Application by WTI/EFW Holdings Ltd for Wheelabrator Kemsley K3 and WKN

The Examining Authority's written questions and requests for information (ExQ1)

Issued on 26 February 2020

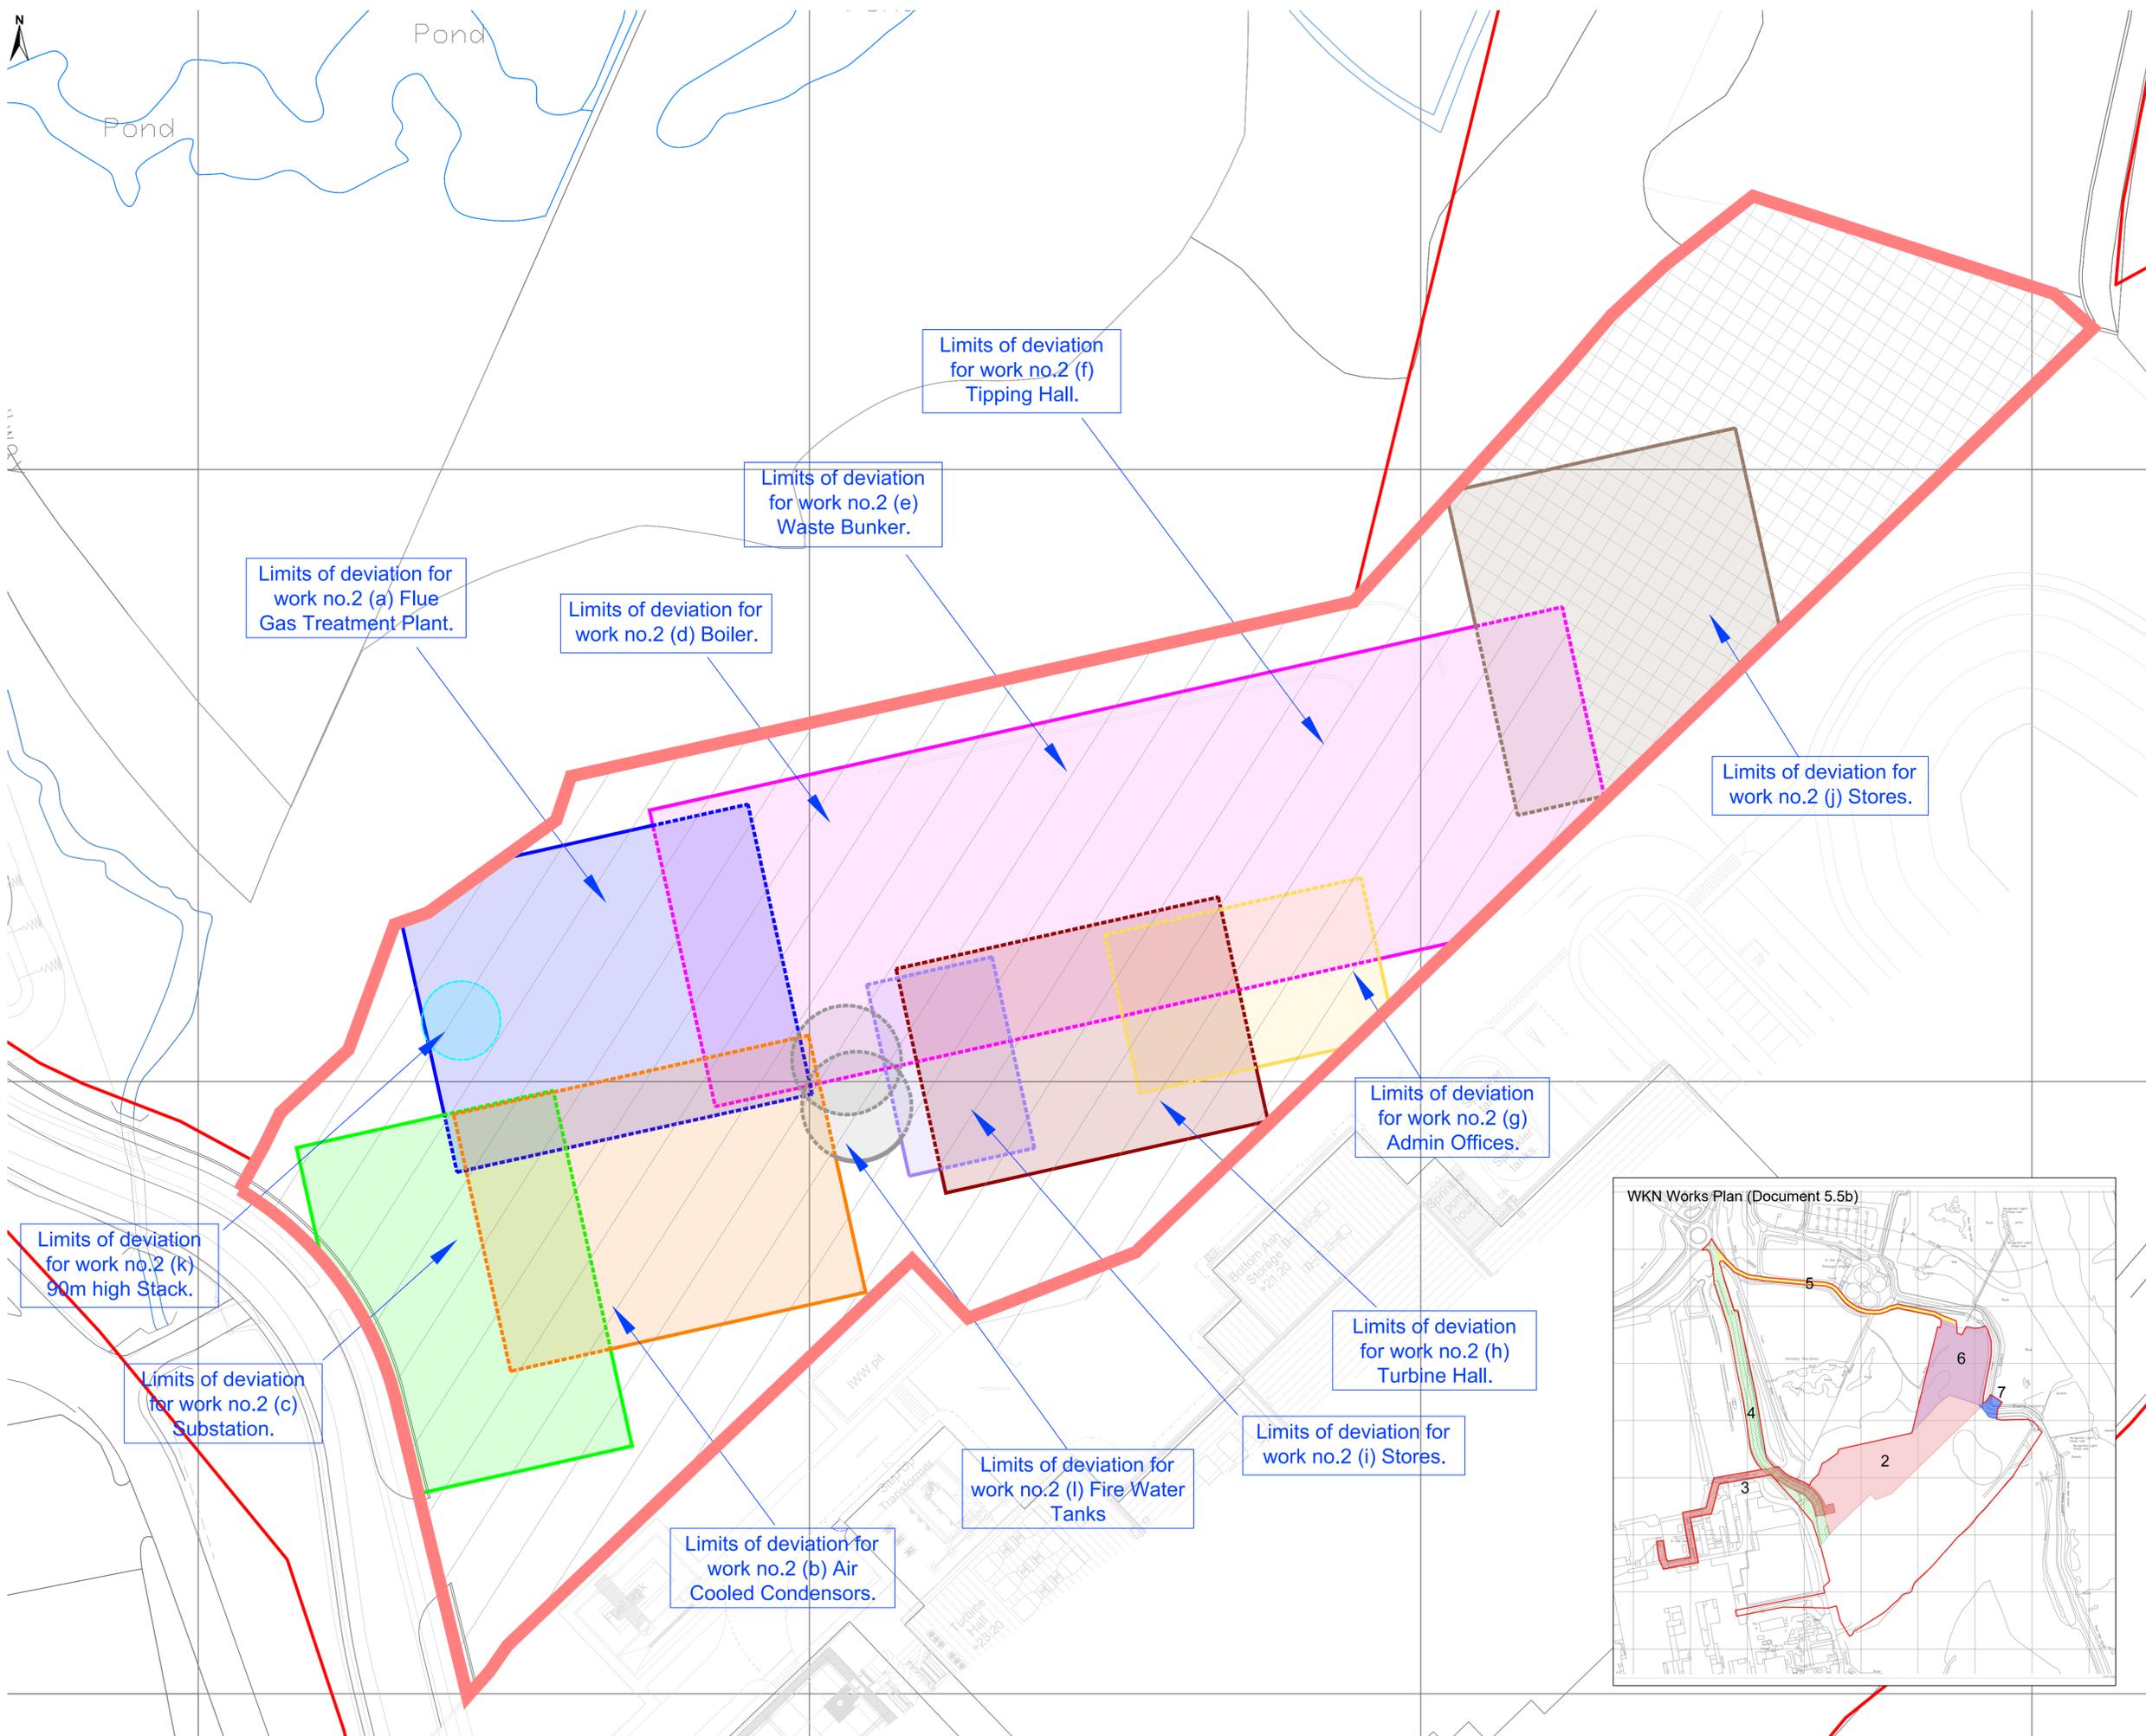
ExQ1	Question to:	Question:
Q1.2.2.	The Applicant	<p>The Work Nos shown on the WKN Parameter Plan contained in Figure 2.9 of ES Chapter 2 are not consistent with the Work Nos shown in dDCO Schedule 1, replicated in R14 Table 1. In addition, dDCO R14(4) defines the WKN Parameter Plan as that certified under Article 16, although it is not one of the plans listed therein.</p> <p>Please explain the discrepancies and provide corrected plans as necessary.</p>
Q1.2.3.	The Applicant	<p>The ES states that the design life of the operational Proposed Developments is up to and potentially beyond 50 years.</p> <p>Explain how this durational design change (which differs from that presented at the scoping stage) has influenced the Proposed Developments in terms of anticipated impacts from climate change?</p>
Q1.2.4.	The Applicant	<p>Table 2.3 of the ES presents a maximum height of 30m for Work No 2(i): administrative office, whereas it is shown as 15m in the dDCO Part 3 WKN Requirements.</p> <p>Please clarify the basis on which the assessments were made and correct the parameter details in the next iteration of the dDCO as necessary, to ensure that there is consistency between the ES and the DCO.</p>
